**PLANNING DEPARTMENT
DEVELOPMENT AND BUILDING SERVICES
HYDROLOGY DEVELOPMENT SECTION**

Re: Lots 7B and 8 Grande Heights Addition, Grading and Drainage Plan
Engineer's Stamp date 9-17-09 (G11/D068)

**Re: Lots 7B and 8 Grande Heights Addition, Grading and Drainage Plan
Engineer's Stamp date 12-22-09 (G11/D068)**

RE: **Lots 7A & 7B Vista Grande Addition** File: G11-D 068
Drainage Report & Plan for Platting, Grading & paving PE Stamp 11-03-08

SHEET
C-101

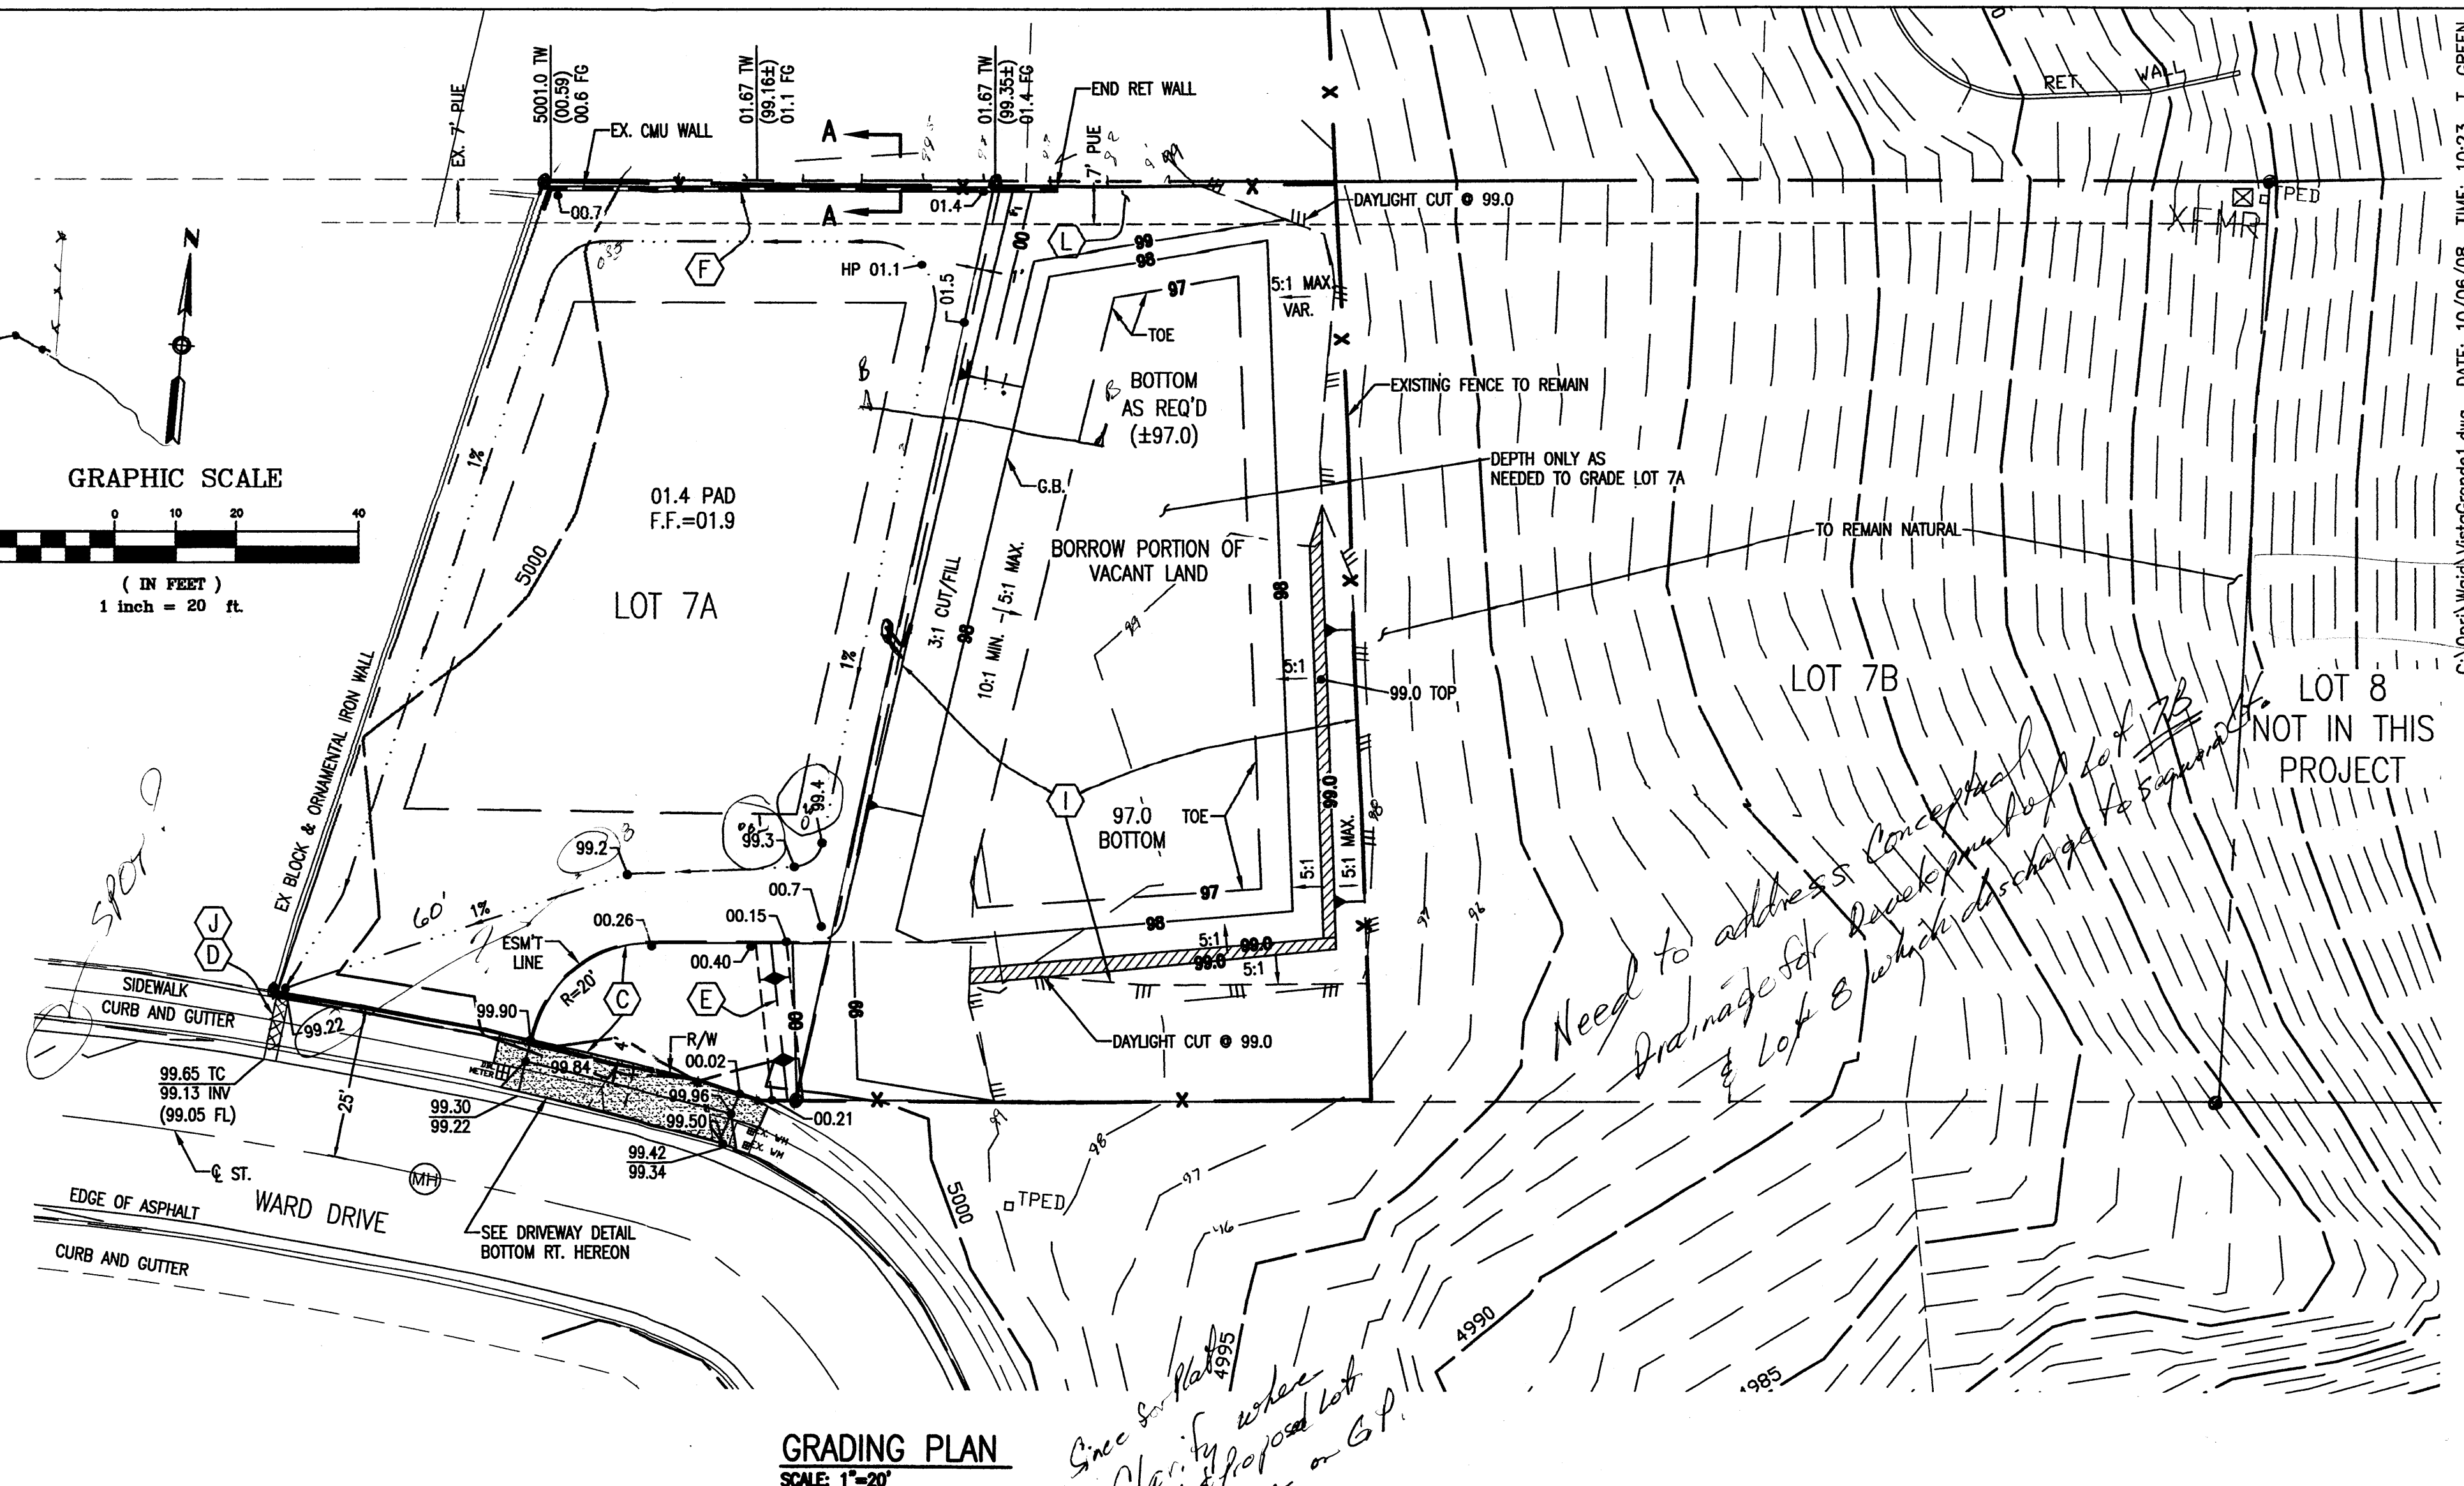
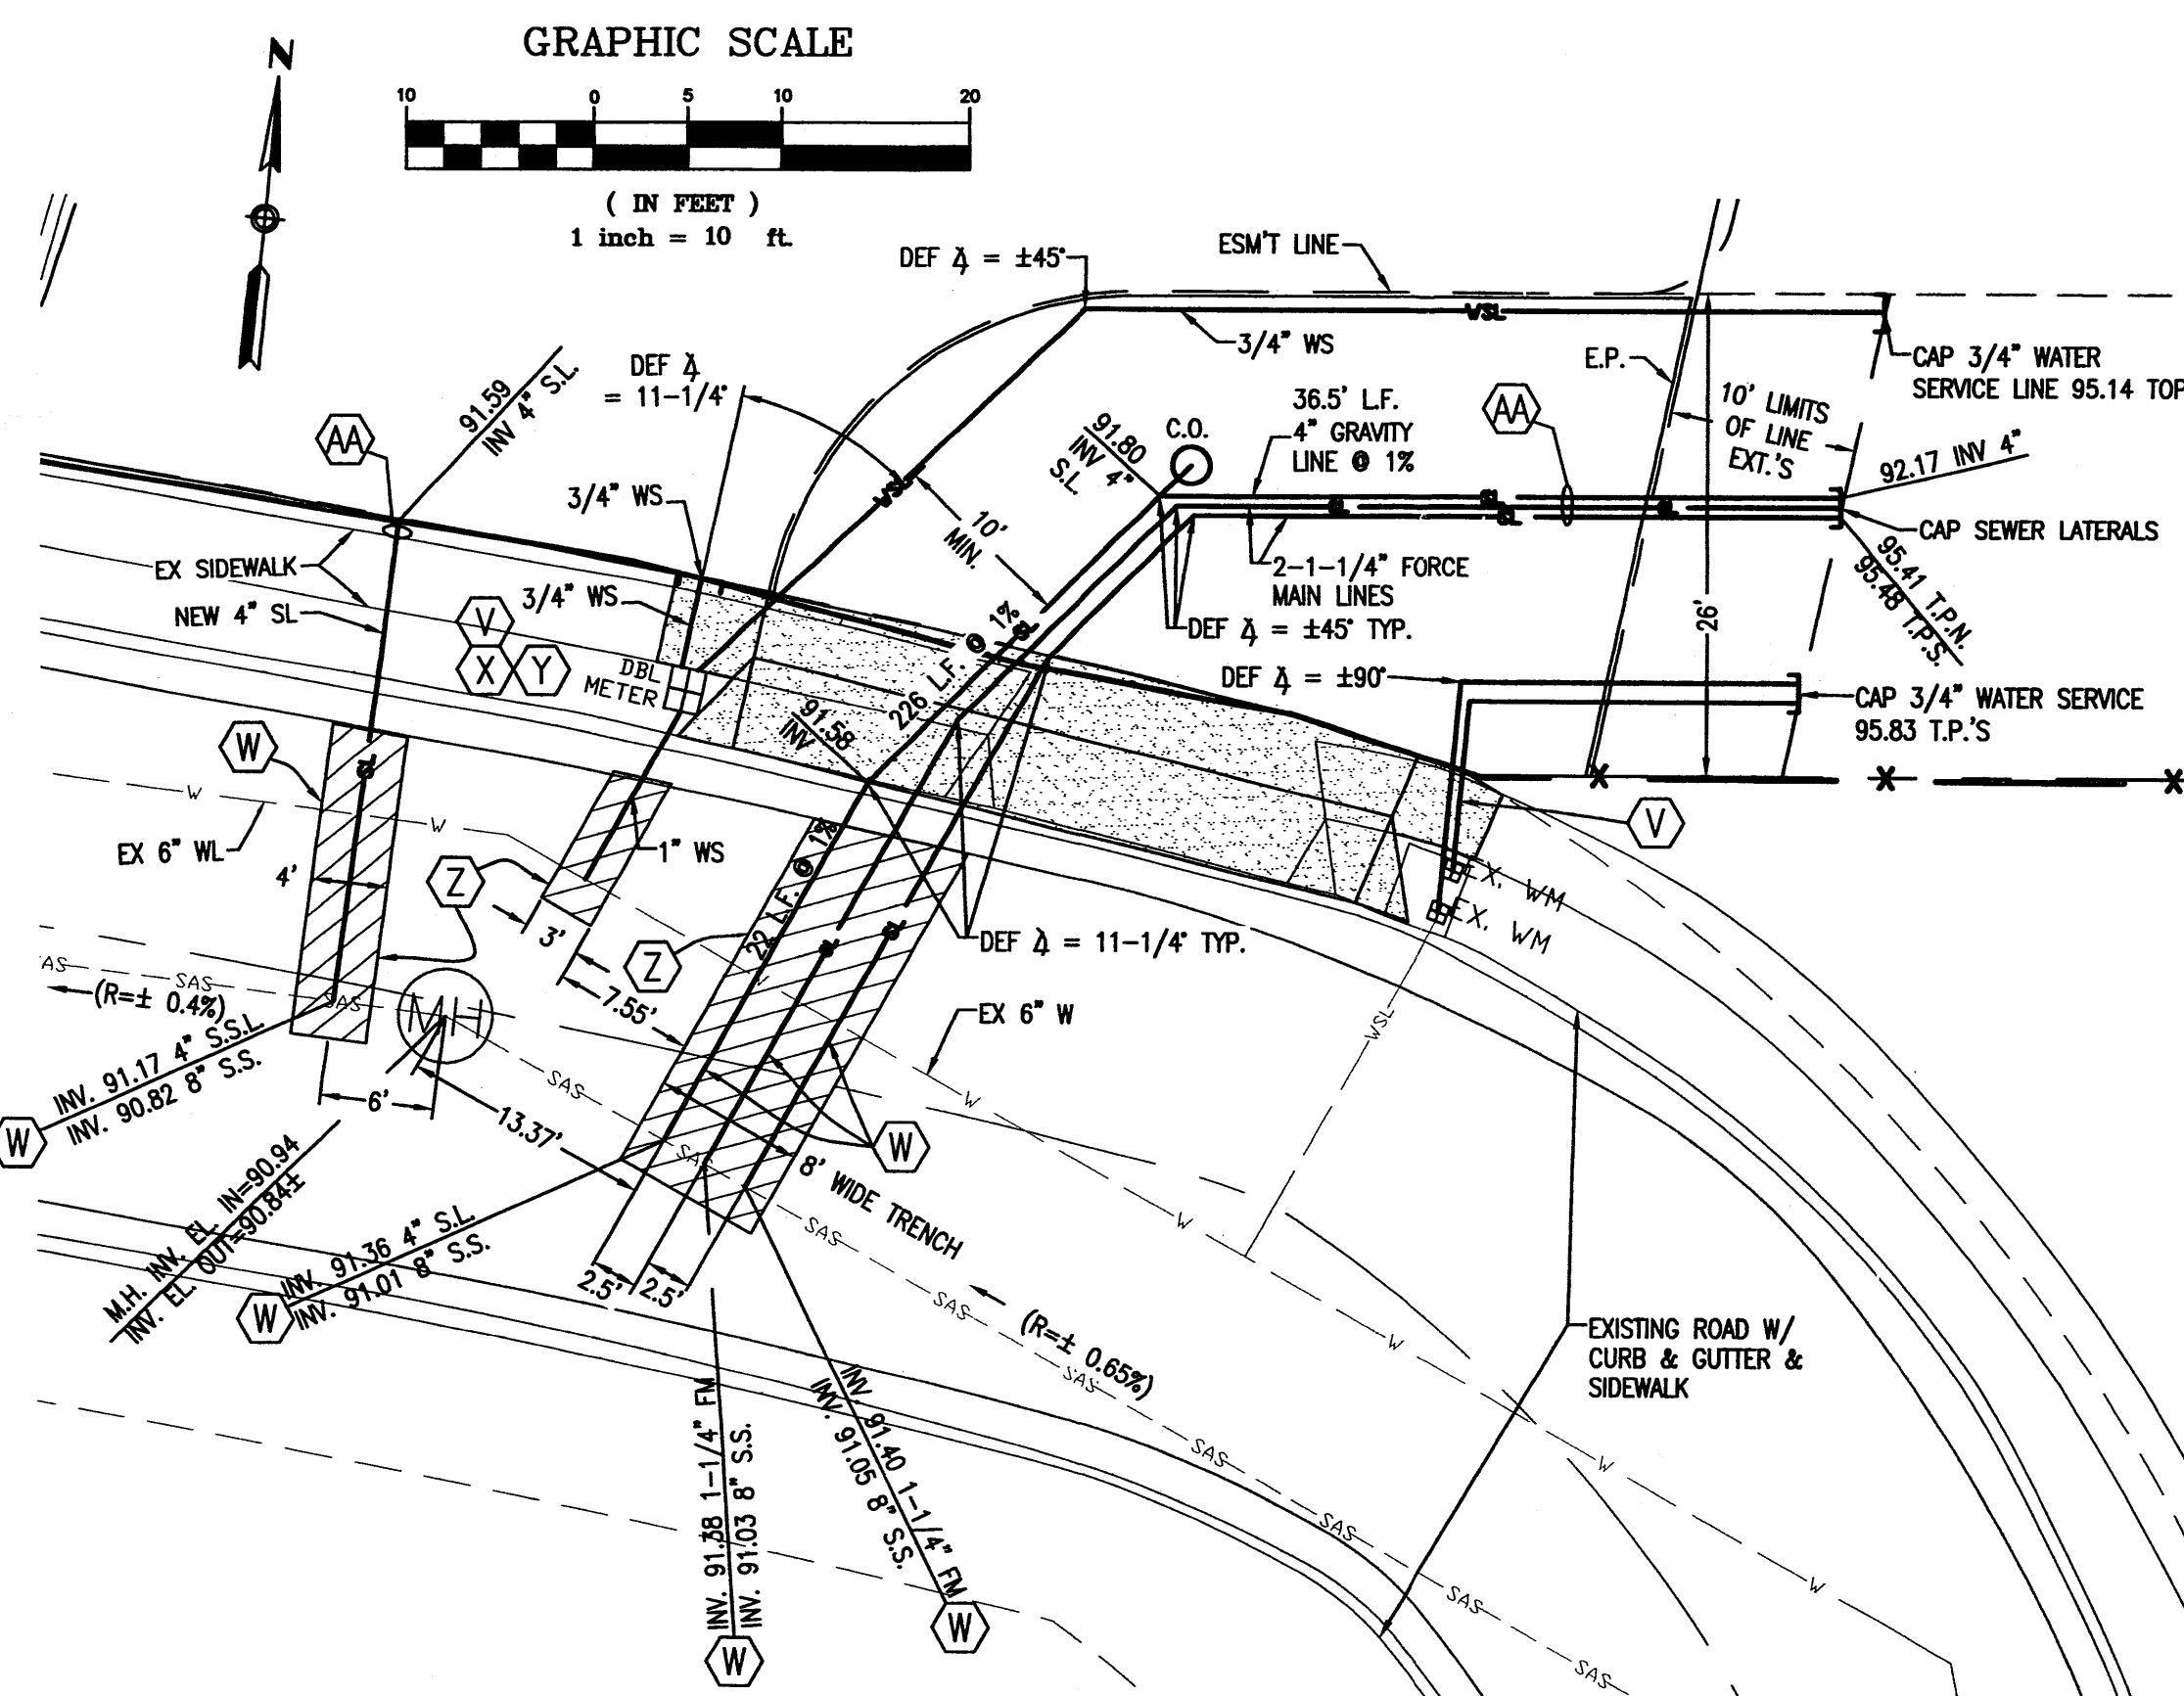
4. On C-101 and in the Drainage Report, Section "Grading and Drainage" clarify with references to proposed Lots 7A and 7B where they are discussed.
5. On C-101, clearly show and label the location of the proposed boundary between Lots 7A & 7B on the Grading Plan and on the Utility and Driveway Plans.

6. On the Grading Plan, verify and correct the spot elevations on the swales around the pad on the western portion of proposed Lot 7A. Provide a spot elevation near the NW corner of the pad and check the ones around the east and south side of the pad, which do not coincide with the 1% grade shown. ***

7. Provide a spot elevation on the existing gutter flowline west of the sidewalk plate to verify that site runoff will flow west on Ward Avenue. pr
